WEST SUSSEX COUNTY COUNCIL CONSULTATION

TO:	Arun District Council FAO: Emma Sheppard
FROM:	WSCC – Highways Authority
DATE:	4 July 2025
LOCATION:	Units 5-7 Watersmead Business Park Norway Lane Worthing Road Littlehampton BN17 6LS
SUBJECT:	LU/93/25/PL Part demolition, conversion, refurbishment and re-elevation of Units 5 and 6 and construction of retail (food and non-food), leisure and food & beverage units (Use Class E), together with associated car parking, access, loading areas, landscaping and associated works. This application is in CIL Zone 2 and is CIL Liable.
DATE OF SITE VISIT:	n/a
RECOMMENDATION:	More Information

title
**PROPOSED HIGHWAY IMPROVEMENTS
AND SITE ACCESS ARRANGEMENT**

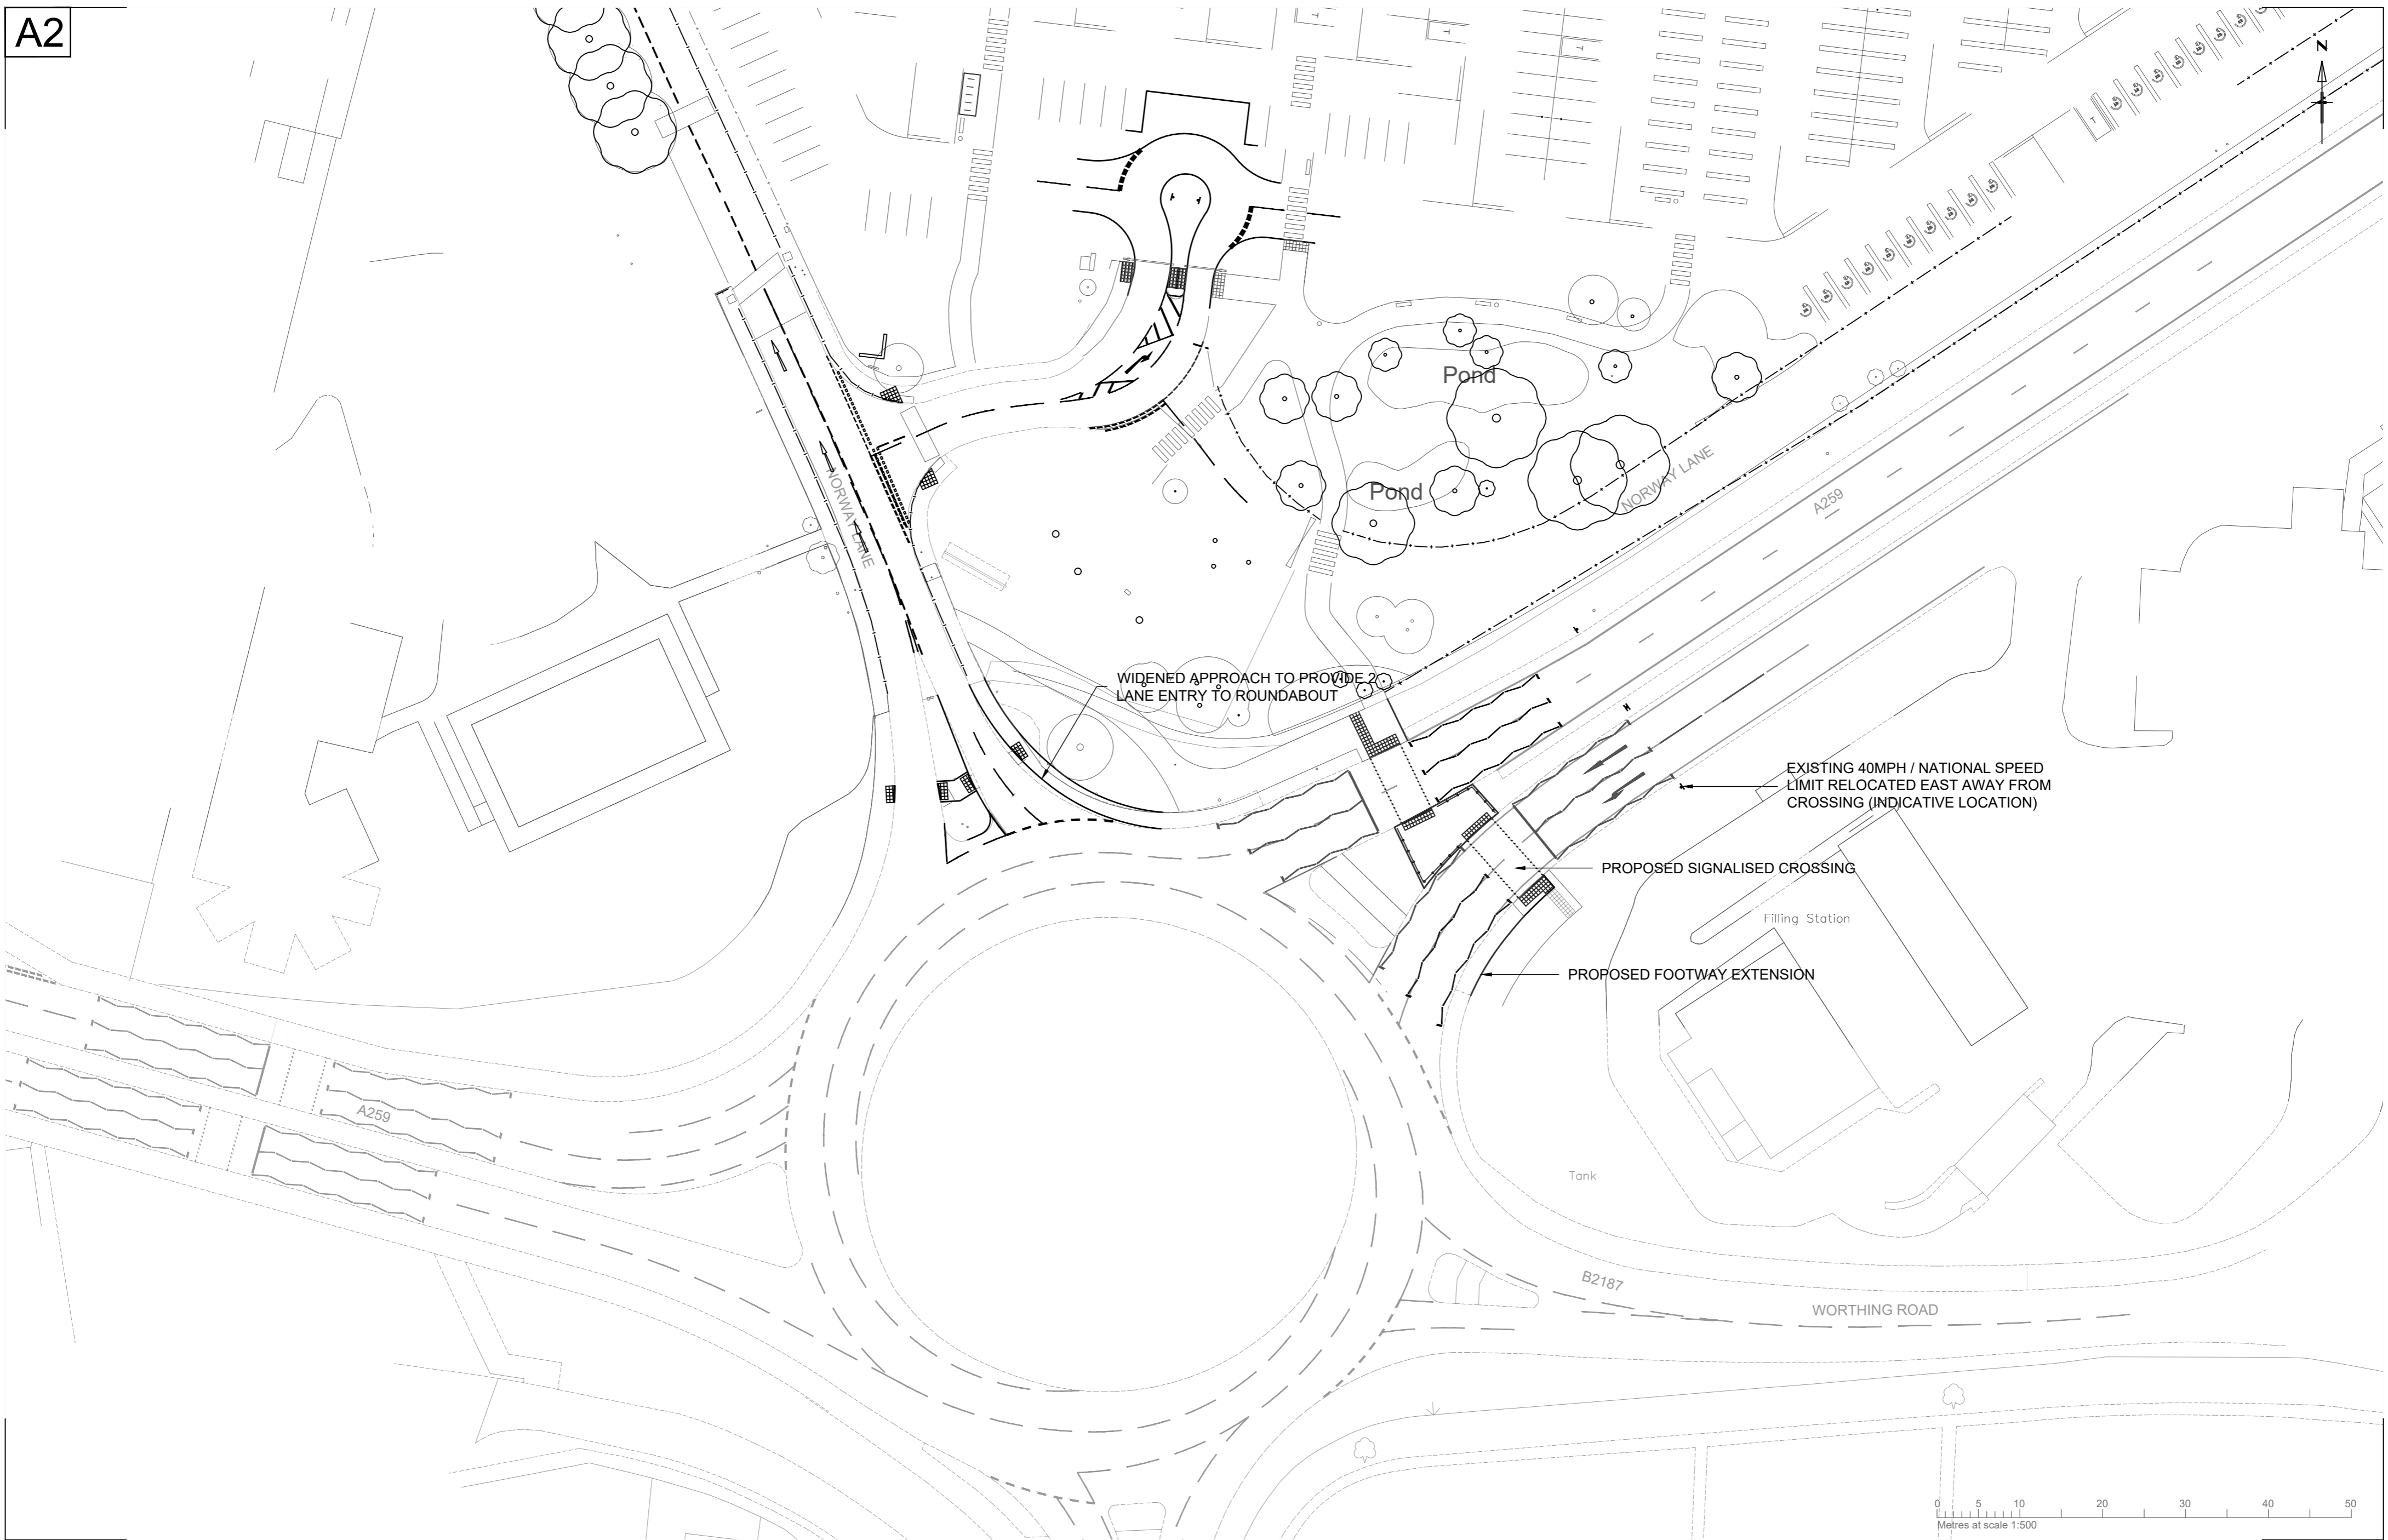
Vehicular access will continue to be taken from the northern arm of 'The Body Shop' roundabout via Norway Lane. This will be widened, between the car park access and roundabout, to accommodate two HGVS using the road to enter the roundabout, as shown on the drawing titled 'Proposed Highway Improvements and site access arrangements' and numbered 24084-010-A.

***For completeness WSCC would ask the applicant to provide a dimension drawing to include the existing and new widths proposed and the new kerb radii proposed for planning approval.**

An additional access will also be created onto Norway Lane at the northwest corner of the proposed car park. WSCC acknowledge this is in private land however we would advise the northwest access is designed to allow two cars to pass with ease and provide visibility spays to match the speed limit of the road.

- A speed limit reduction is essential here.
- A maintenance bay/identified safe location to park will be required to facilitate all visits to site by ourselves/our maintenance contractor, positioned on the same side of the carriageway as the controller.

- There will need to be at least 3m offset between two crossing points. With this current layout, I would recommend the southern crossing point is moved further away from the roundabout, preventing reduction in queuing space for eastbound traffic that could impact the roundabout.

- Consideration should be given by the designer into minimising the potential for see-through of the Green Man (as suggested within the attached image; the far-side Green Man can be observed, and pedestrians could become confused and walk into live traffic), when waiting on the outer-most crossing points. We have found that this can be overcome by either increasing the offset between crossing points, or by reversing the direction in which non-motorised users turn, when in the centre island.

***Please can the applicant ensure all these points have been addressed and sent back to the LPA for approval in an updated drawing.**

- **More consideration needs to be given to the provision of shared use footways linking into the toucan crossing as the current drawing only shows a footway when there is already a shared use path on Worthing Road it could connect into for consistency.**
- **On the western side of Norway Lane, the shared use cycle route in the highway boundary terminates abruptly, away from any dropped kerbs, or connections for a cyclist to enter the site.**

***Please can the applicant ensure all these points have been addressed and send back to the LPA for approval in an updated drawing**

**Designer Response -
Appendix 1**

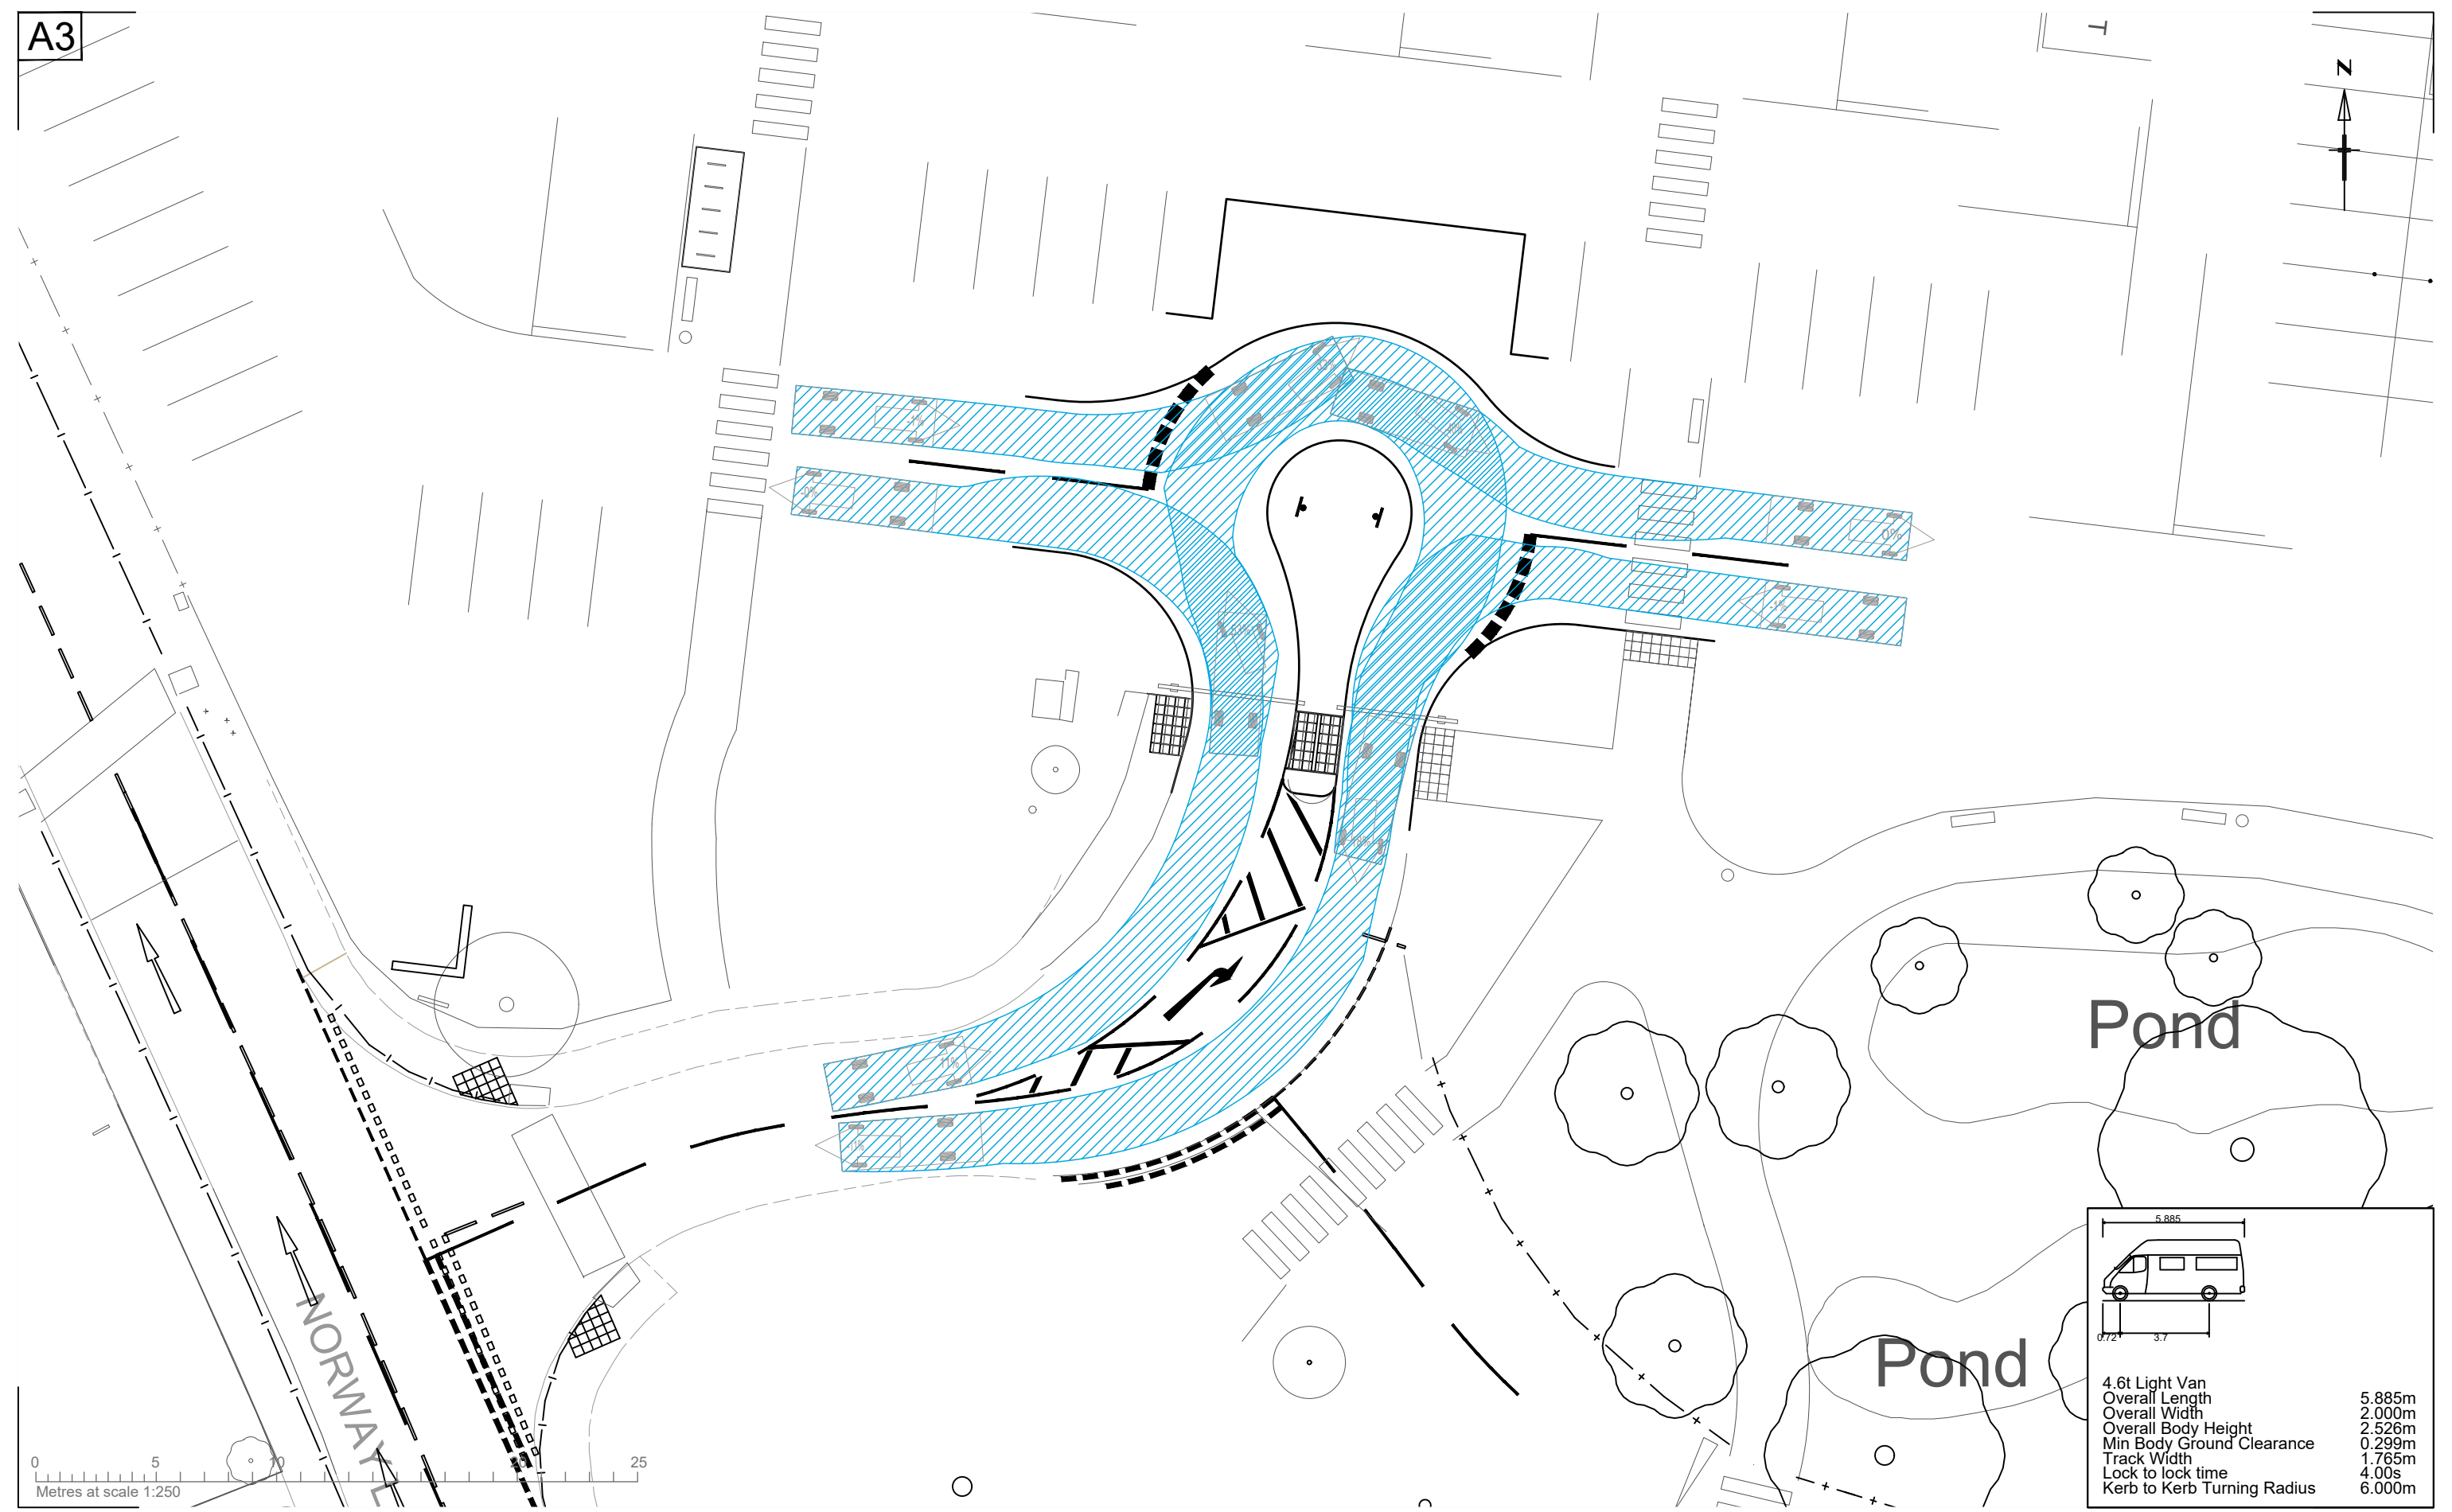
<i>inbound lane when turning right.</i>	<i>occur as drivers waiting /slowing from right turning vehicles in front is commonplace occurrence regardless of whether the vehicle fits partially or wholly within any right turn lane</i>	<i>auditor to come to an agreed plan of action.</i> <i>It is not considered that the right-hand turn lane would cause issues if it was left in place or if it was taken out as the number of people making this movement would be low.</i>	
<i>4.2 – see RSA</i>	<i>It is recommended that a swept path analysis is undertaken for the proposed new development to make sure all vehicles that will be using the turning area on the approach to the parking can be accommodated.</i>	<i>The car parking area is intended to be used by car and van sized vehicles only those that would fit in a standard car parking spaces. A swept path analysis of a large van turning in and out of the parking area is shown on plan ‘proposed site access improvements swept path analysis 4.5 tonne rigid vehicle’ – 24084-sk20250402.1</i>	<i>Agreed.</i>	<i>Agreed. Plan ‘proposed site access improvements swept path analysis 4.5 tonne rigid vehicle’ – 24084-sk20250402.1 to be included as part of the final planning approval.</i>
